From: George Smith
Sent: 21 November 2019 15:12
To: DC Support
Subject: FW: 19/02075/F - The Old Vicarage

From: Iain Osenton <iain.osenton@cherwell-dc.gov.uk>
Sent: 21 November 2019 15:06
To: George Smith <George.Smith@Cherwell-DC.gov.uk>
Subject: RE: 19/02075/F - The Old Vicarage

Iain Osenton
Arboricultural Officer (South)
Environmental services
Cherwell District Council

Site Plan
AS PROPOSED
Scale 1:200

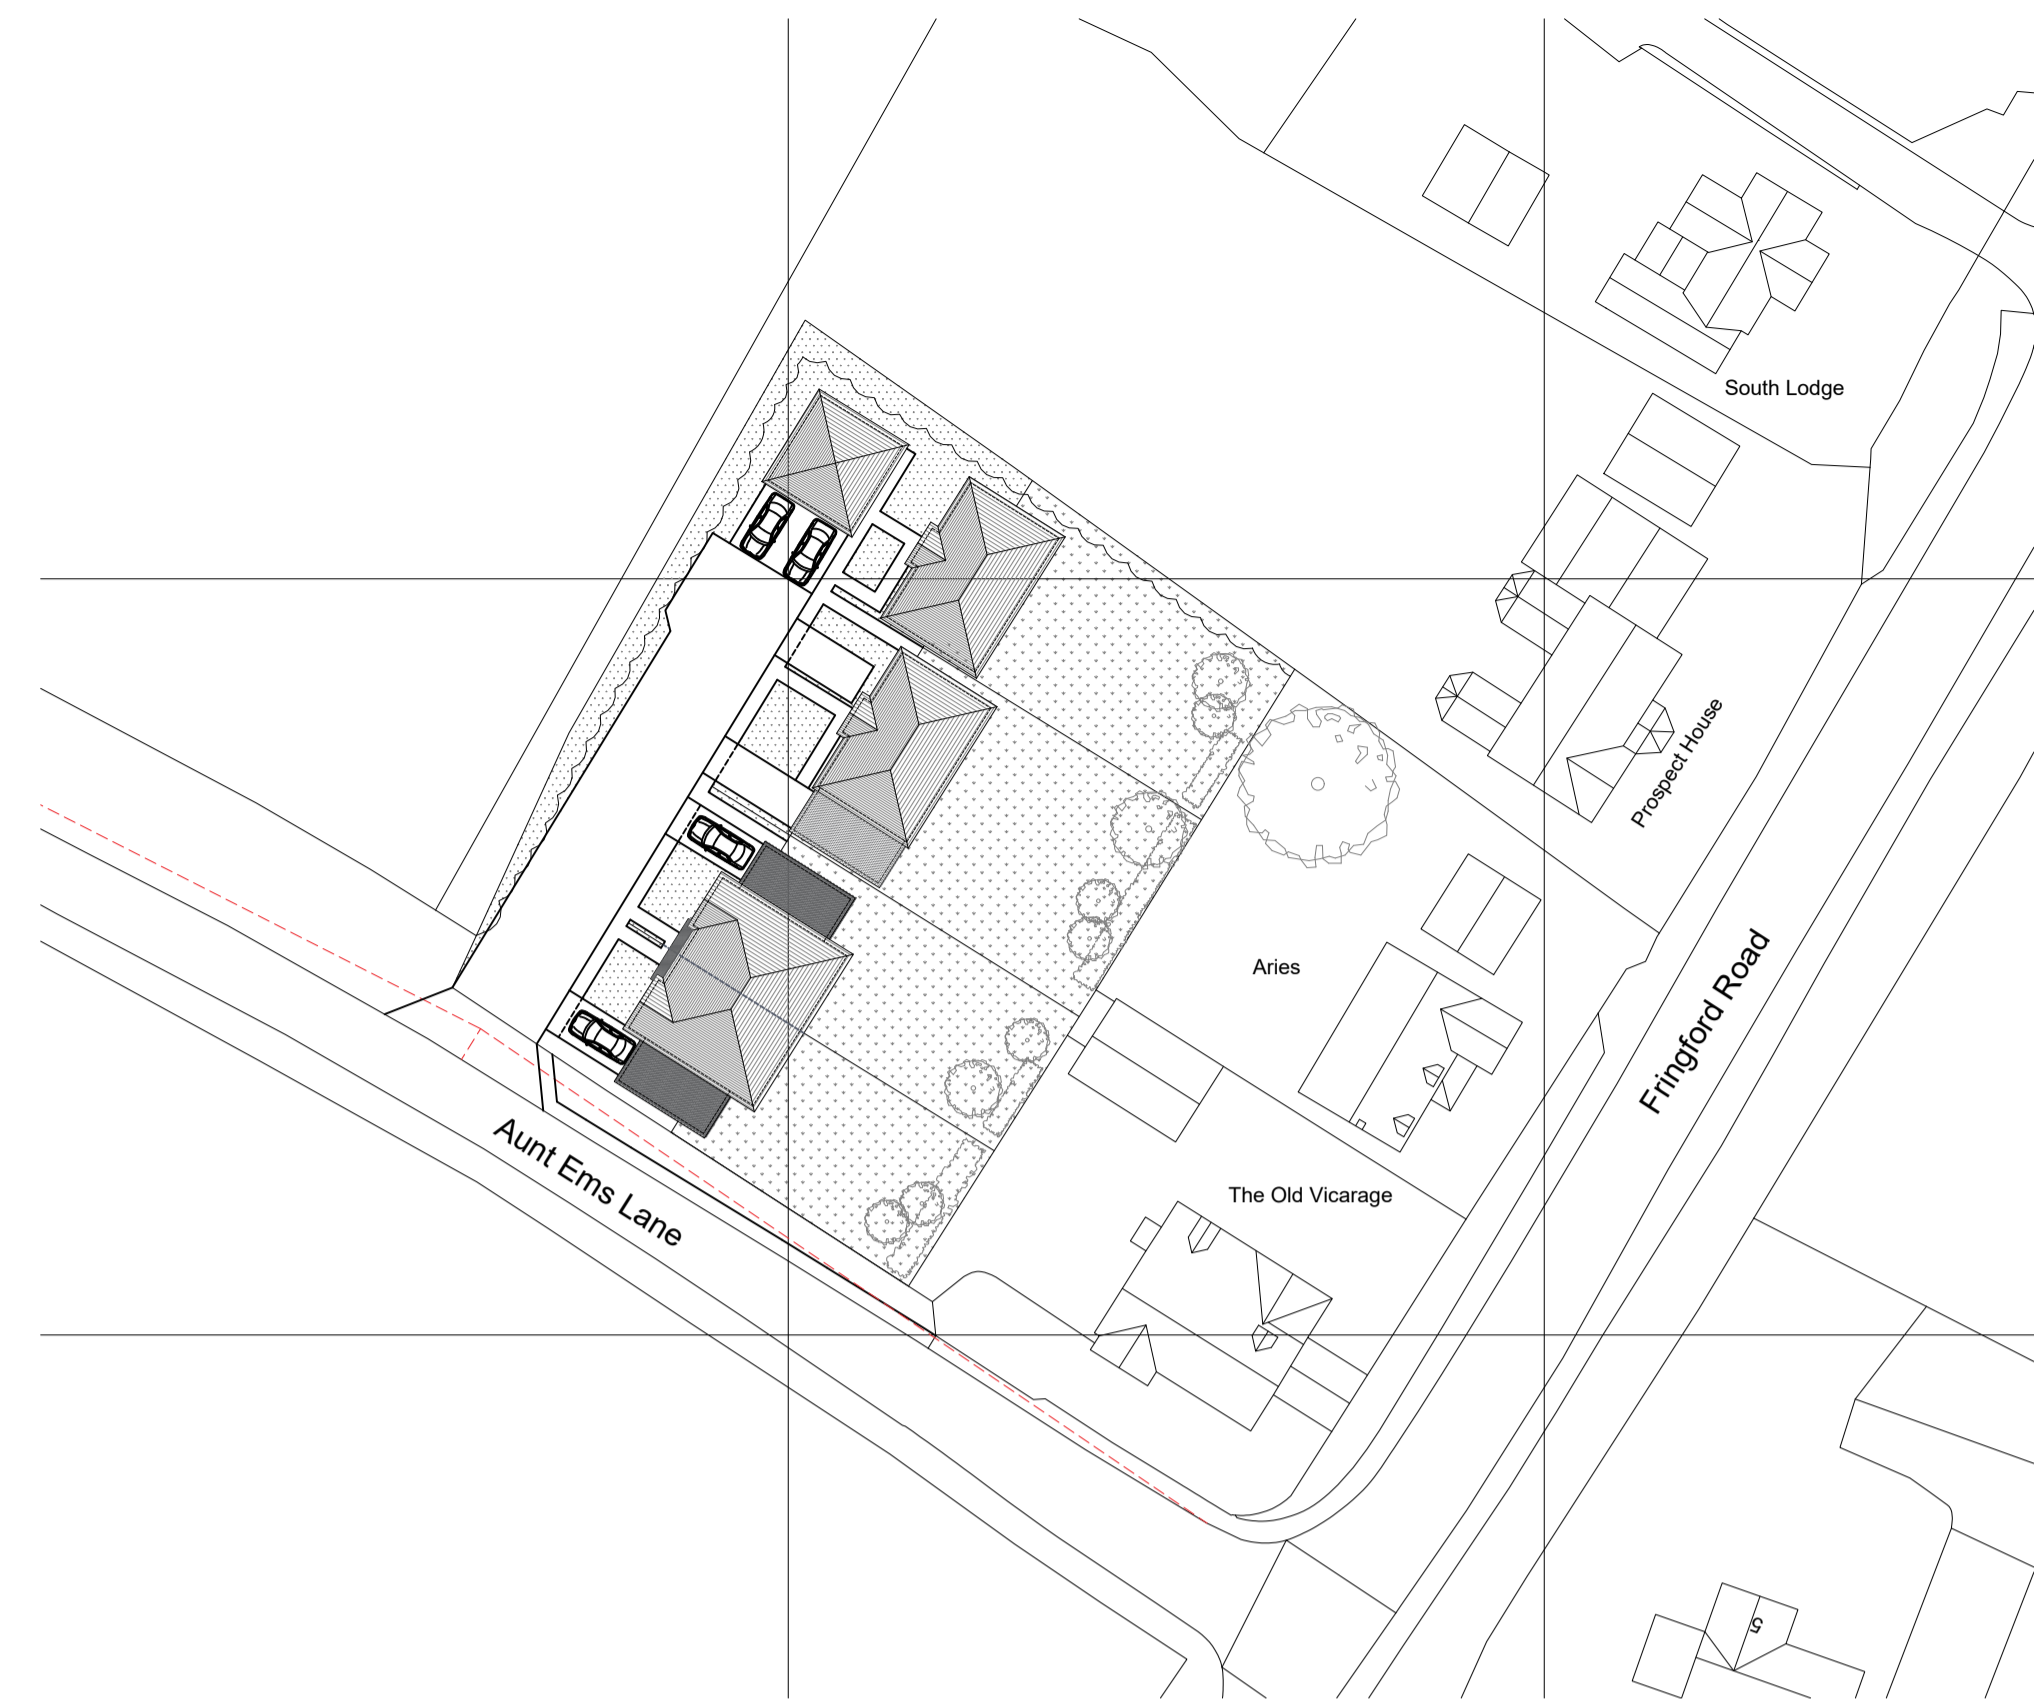
Regarding the hedge, I'm still concerned the amount of shade offered by the hedge to the north most property will be a cause of dispute between the property/hedge owner once occupied.

Regarding the planting, I'm happy for this to be conditioned as discussed.
